Your ref:	Henry Wood House - Courtyard	Please reply to:	Mr Joshua Wilson
Our ref:	24/00466/FULL	Tel No:	
		Fee Queries:	0207 641 6500;
		Email:	planningreception@westminster.gov.uk;
- - Gerald Eve LLP Gerald Eve LLP Gerald Eve LLP One Fitzroy 6 Mortimer Street London W1T 3JJ United Kingdom		Incomplete Applications Town Planning & Building Control City of Westminster PO Box 732 Redhill, RH1 9FL	
		29 January 2024

Address: Henry Wood House, 2 Riding House Street, London, W1W 7FA,

Proposal: Refurbishment of the existing courtyard, including provision of outdoor furniture including seating and planters, installation of lighting, speakers and power sockets, relocation of a bicycle store and provision of additional bicycle parking, erection of a security gate and fence, and other associated works

SHEET NUMBER
I- PA-3 Courtyard- 359- XX

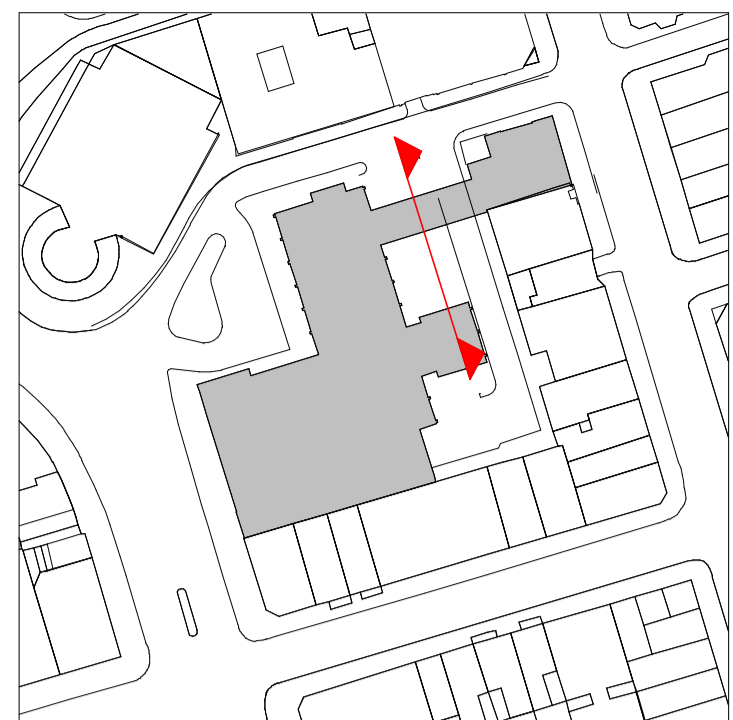
- Drawing, 'Existing East Elevation to Courtyard - I- PA-3 Courtyard- 359- XX' and 'Proposed East Elevation to Courtyard - I- PA-3 Courtyard- 366- XX.' are labelled incorrectly.

Please can this be rectified?
